City of Albuquerque

RE: REVISED ENGINEER CERTIFICATION FOR S.O. 19, SIDEWALK CURB AND
RAILROAD TIE, EARTH RETAINING STRUCTURE (D19/D1C) REVISION DATED
8/25/92

RE: ENGINEER CERTIFICATION FOR S.O. 19 AND INFRASTRUCTURE ITEMS FOR
SANTA BARBARA SUBDIVISION (D19/D1C) REVISION DATED 7/29/92 AND
8/14/92 AND 8/21/92

RE: REVISED DRAINAGE PLAN FOR S.O. #19 @ SANTA BARBARA SUBDIVISION
DRAINAGE CHANNEL (D-19/D1C) REVISION DATED JULY 1, 1992

RUN-DOWN CHANNEL PLAN

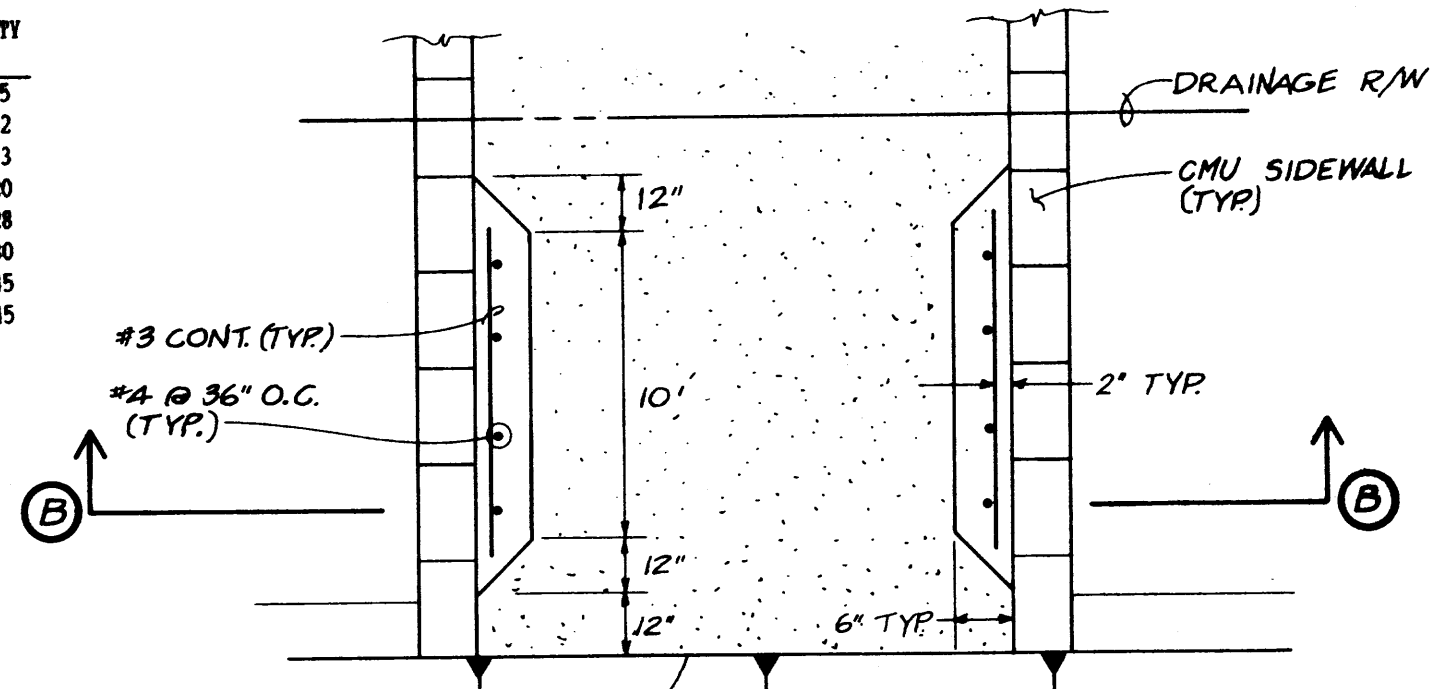
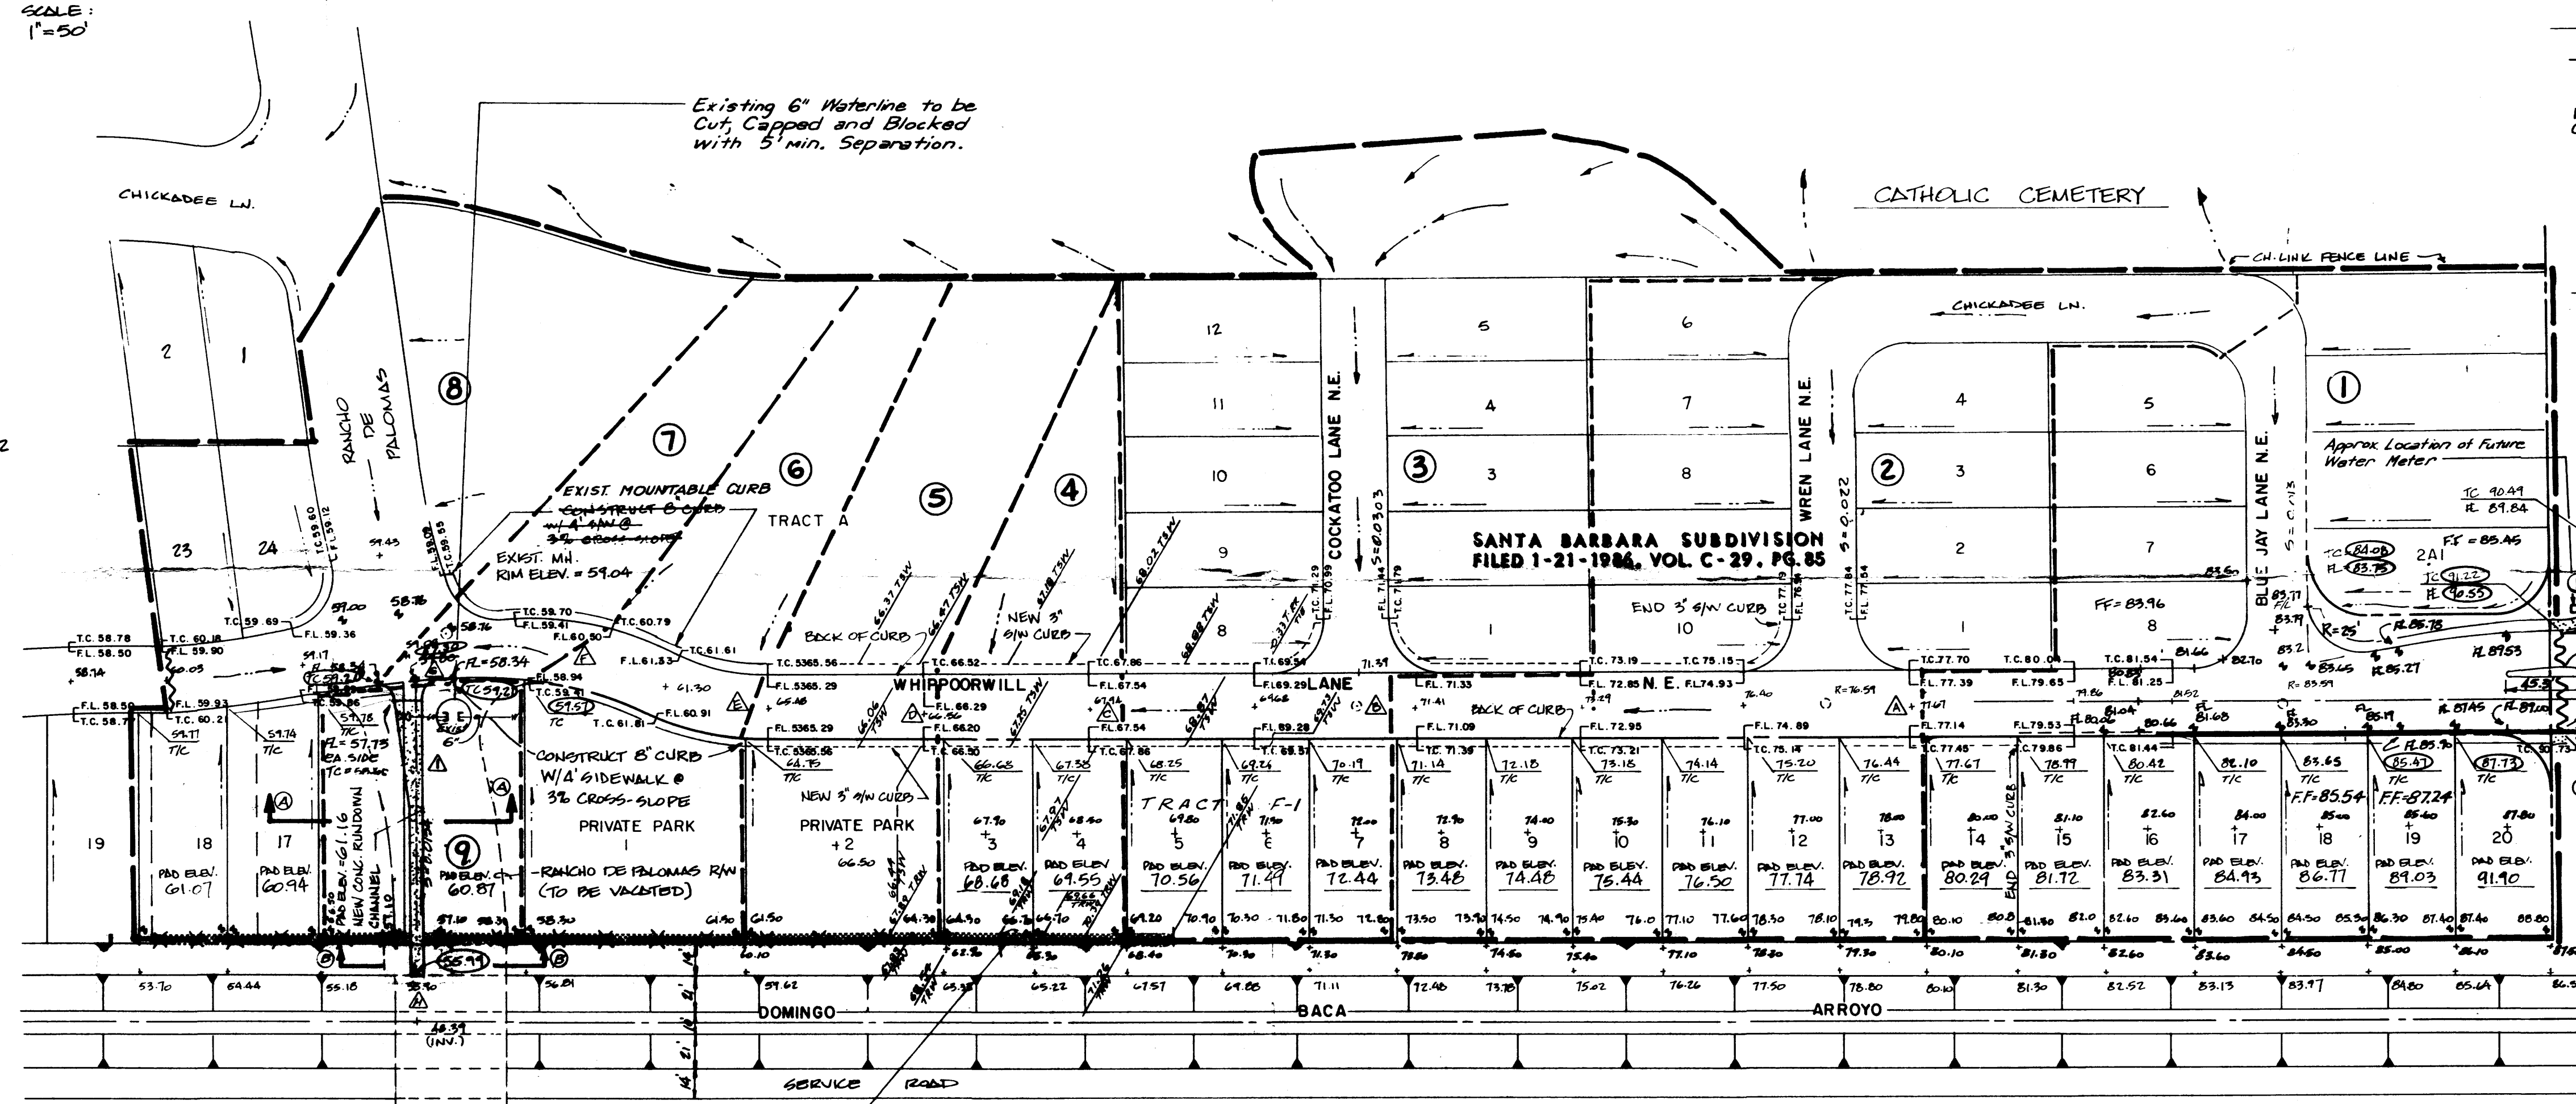
1. Plan drawing must include Engineer Certification Statement which identifies that the site was built in close compliance to the original approved drainage plan. Must be stamped, signed and dated.
2. As-built information must be provided for the drainage run-down, new 8" inch and 3" inch sidewalk curb and top of railroad retaining wall structure.

A field investigation was conducted on June 23, 1992 and it was found that what your updated plan indicates as as-built information does not exist out in the field.

I am confused as to what you are requesting. It is my understanding that a new design for the maintenance road crossing was supposed to be submitted for review and approval by myself and Mr. Glenn Jurgensen from Arroyo Maintenance. Once the new design is accepted and constructed, the Engineer's Certification is required prior to final plat approval.

Please be advised that prior to Preliminary Plat approval, the hydraulics for the rundown must be submitted with the revised drainage plan (recommend that you check the entrance using the weir equation and then the Mannings Equation for the channel).
